Engineers Comments Regarding Surface Water Drainage

Application Reference:	P/6/26/PL	Reviewer Reference:	ADC/EXT5/AF
Planning Officer:	Harry Chalk	Date of Review:	11/03/2026
Site Name:	Fairhaven Nyetimber Lane Pagham PO21 3JT		
Application Description:	Construction of 3 No. detached chalet bungalows together with alterations to existing dwelling with the provision of modified access, parking & landscaping. This application is in CIL Zone 4 and is CIL Liable as new dwellings.		
Assessment Number:	1

Preliminary Levels and Drainage Layout

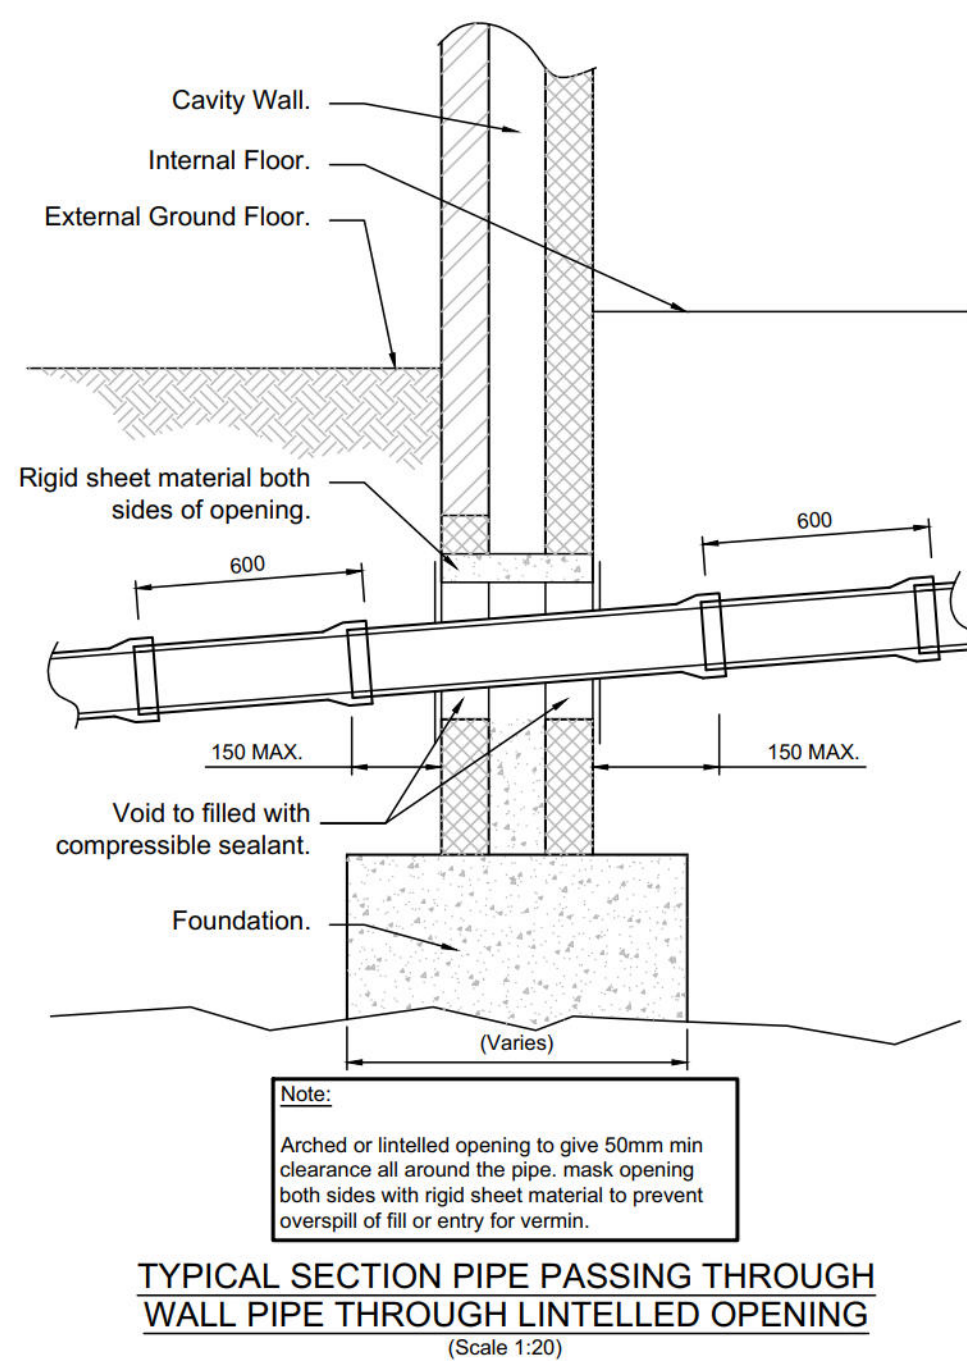
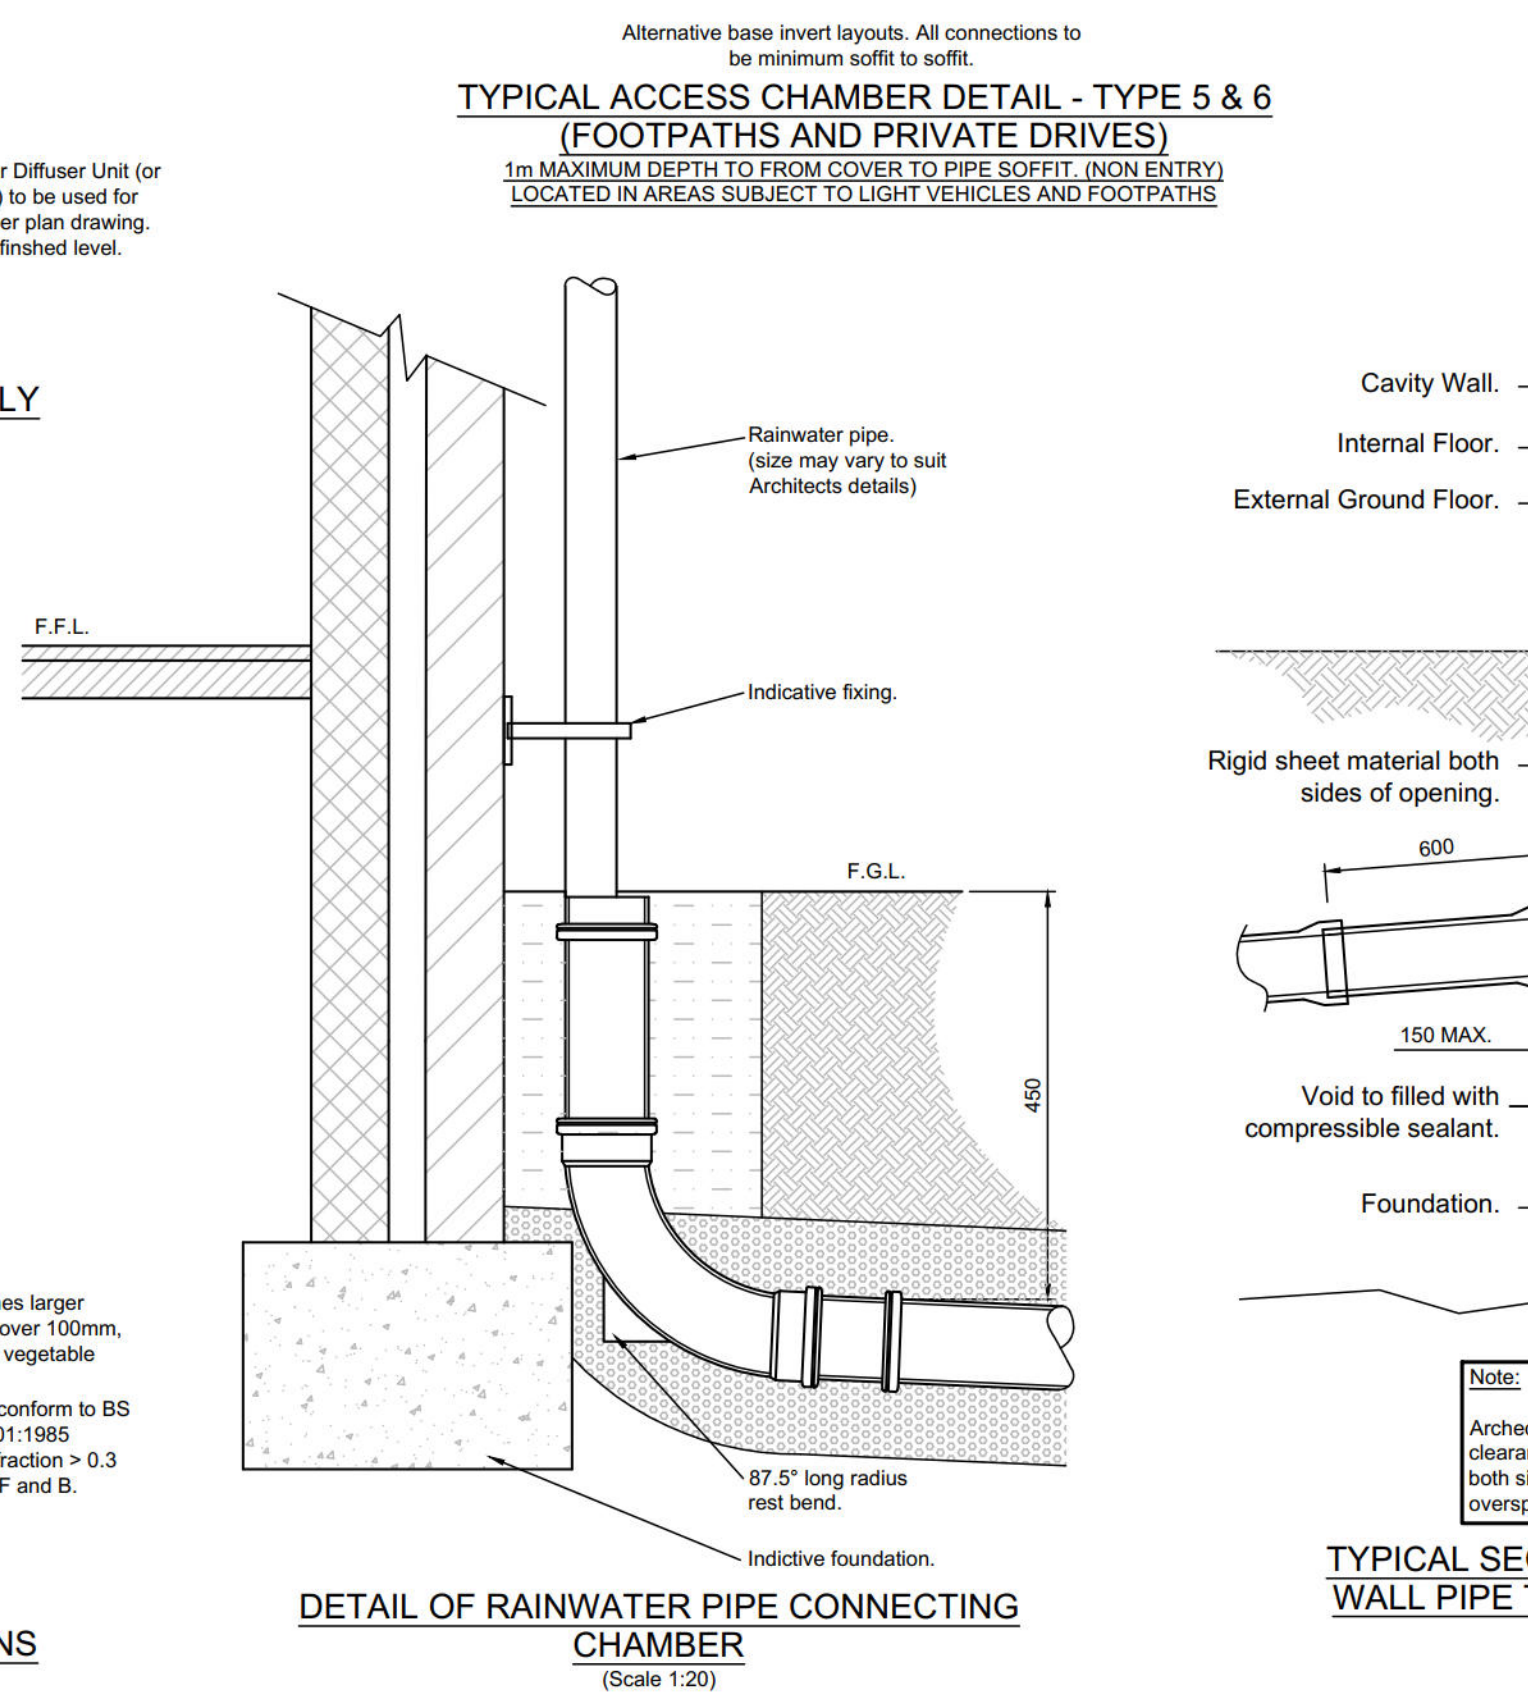
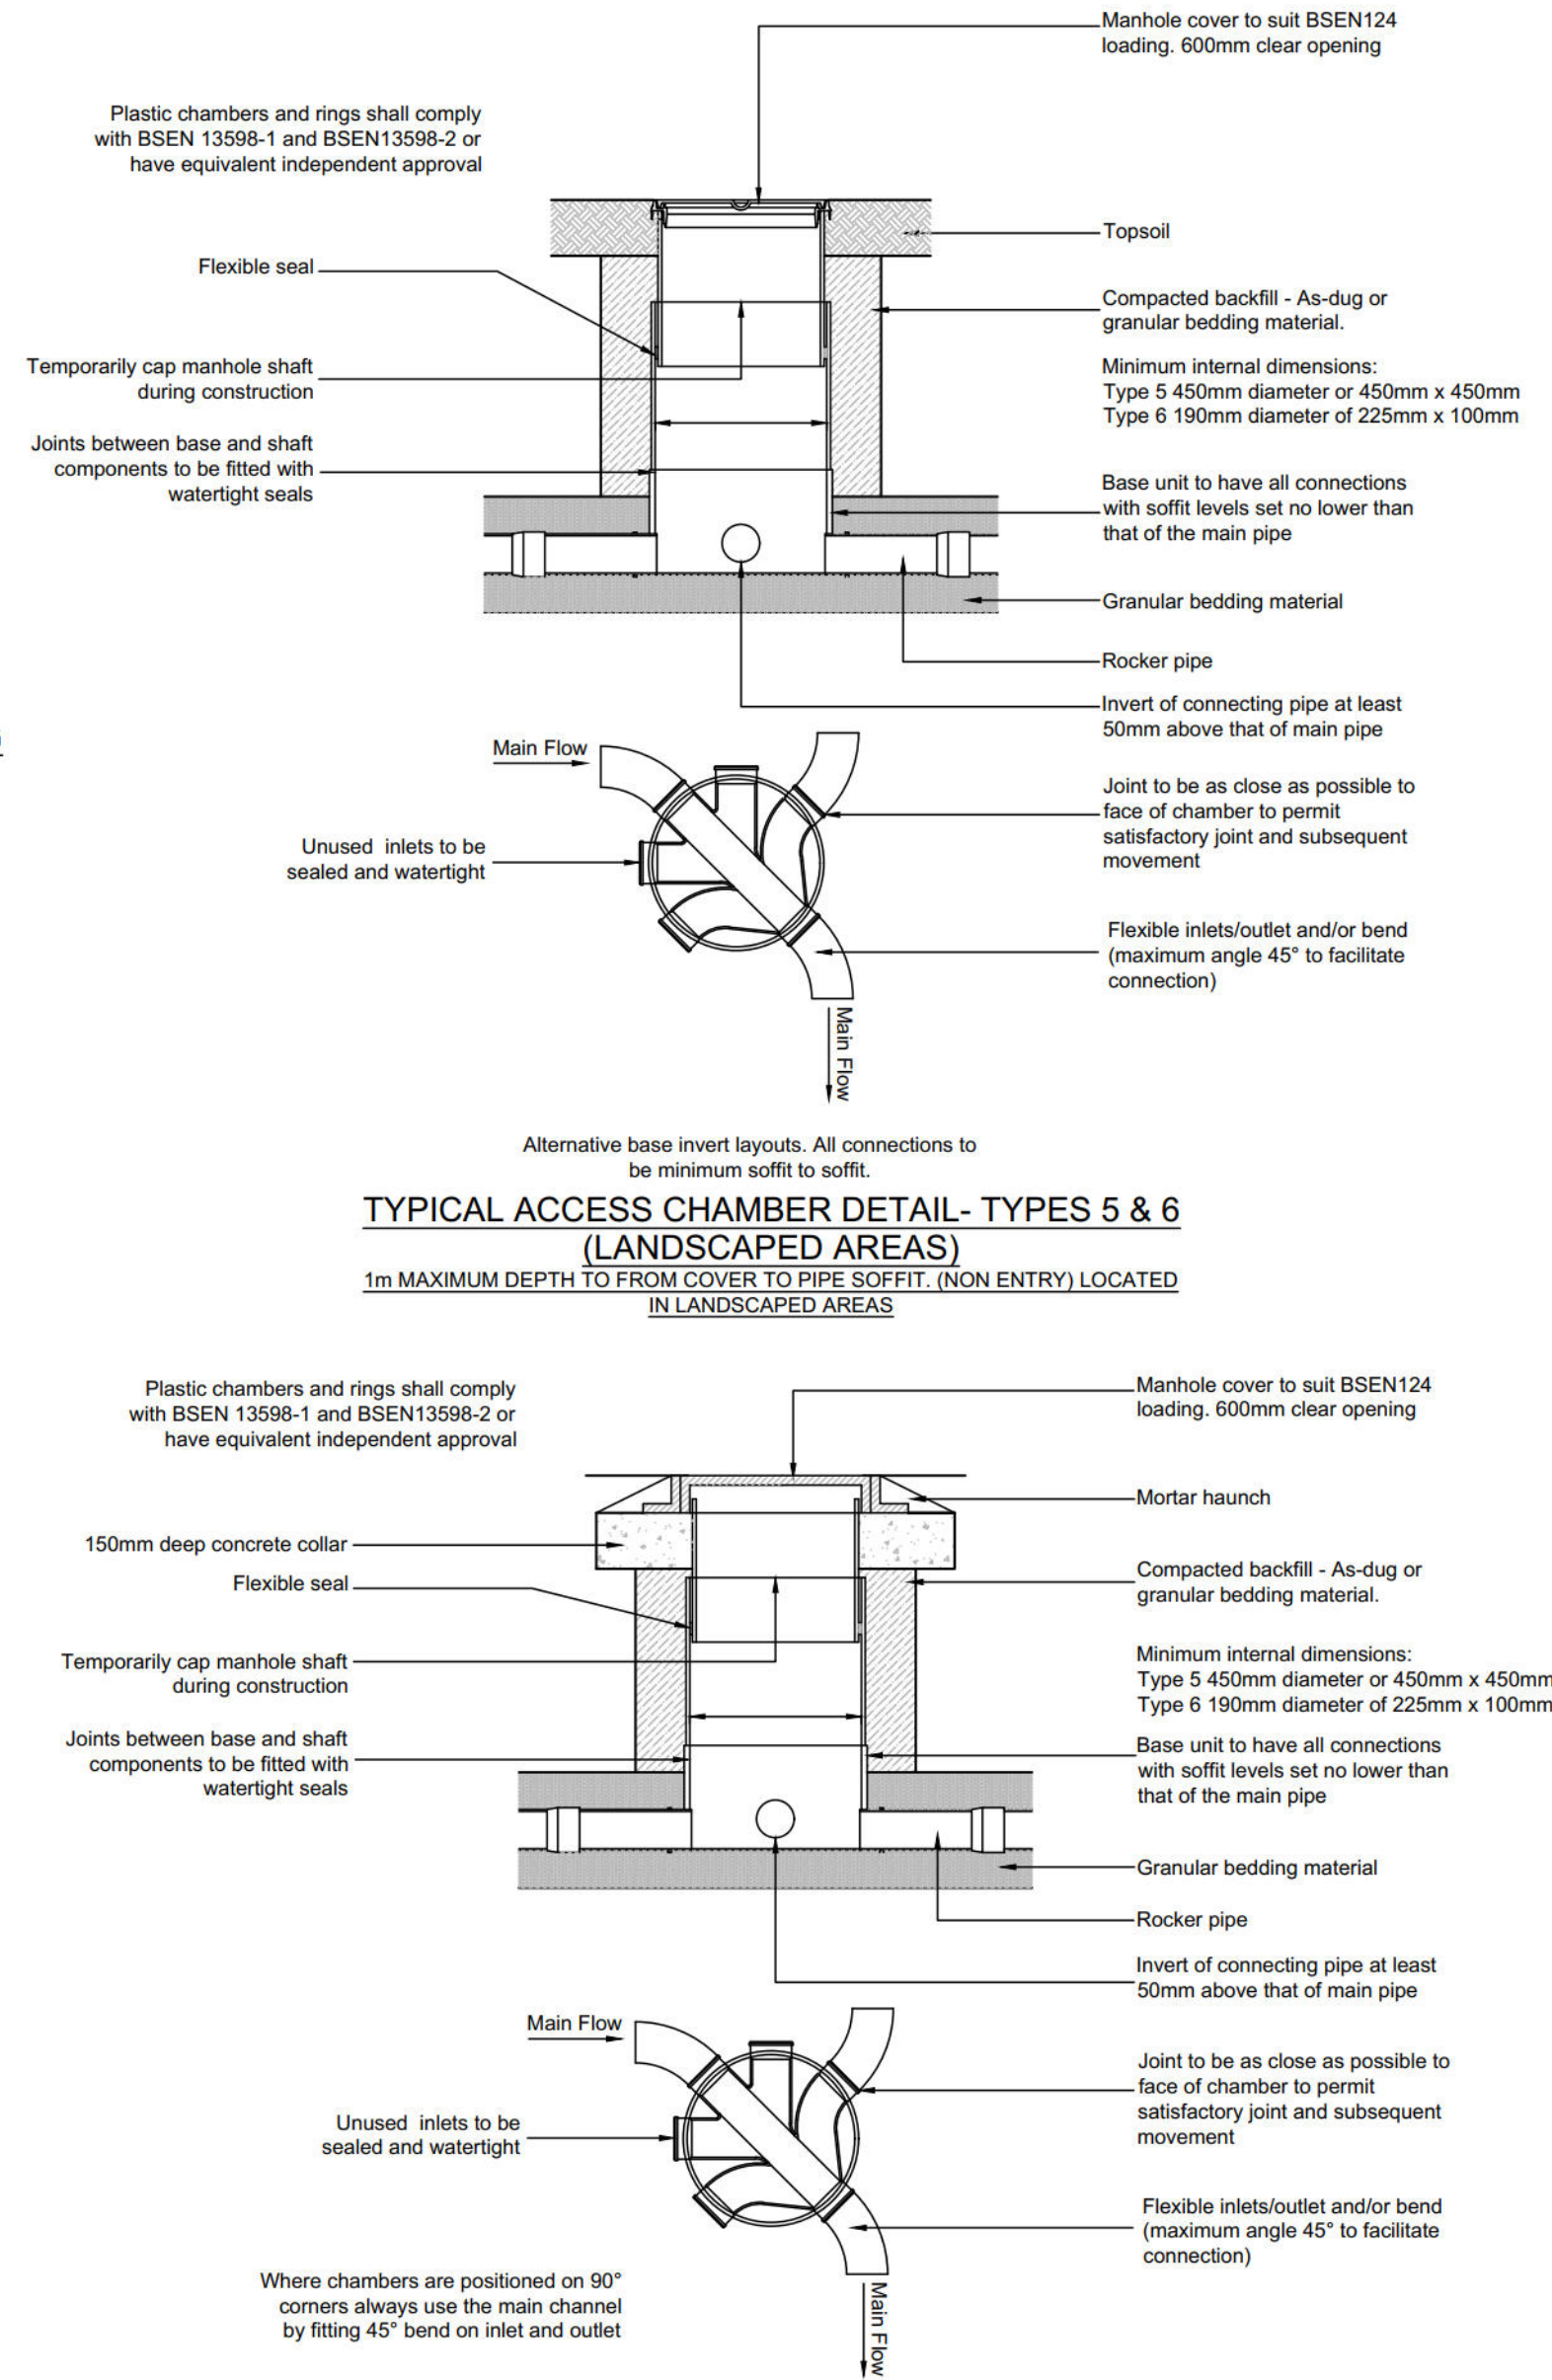
- 1.1. The development should include an element of rainwater harvesting in accordance with the NSfS. The drainage layout shows water butts, which is acceptable for residential dwellings.
- 1.2. The ground investigation confirms shallow groundwater levels within 1m of the surface which preclude discharge to ground via soakaways. There are no watercourses available to the development. The proposed method of disposal of discharge to a surface water sewer is therefore acceptable.
- 1.3. Runoff destination is acceptable.

- 2.1. Inception drainage is not discussed in the submitted Drainage Statement.
- 2.2. The design includes lined permeable paving which serves the self-drained paved area of the driveway. The roof areas require separate interception drainage to accord with requirements within the NSfS.
- 2.3. Evidence has not been provided to justify the lack of interception drainage for the buildings provided as part of the sustainable drainage design. Inception drainage is not currently in accordance with the requirements of the NSfS (Standard 2). Therefore, we **object** to the application.

- 3.4. Exceedance flow paths should be shown on the drainage layout.
- 3.5. Management of extreme rainfall is not currently in accordance with the requirements of the NSfS (Standard 3). Therefore, we **object** to the application.
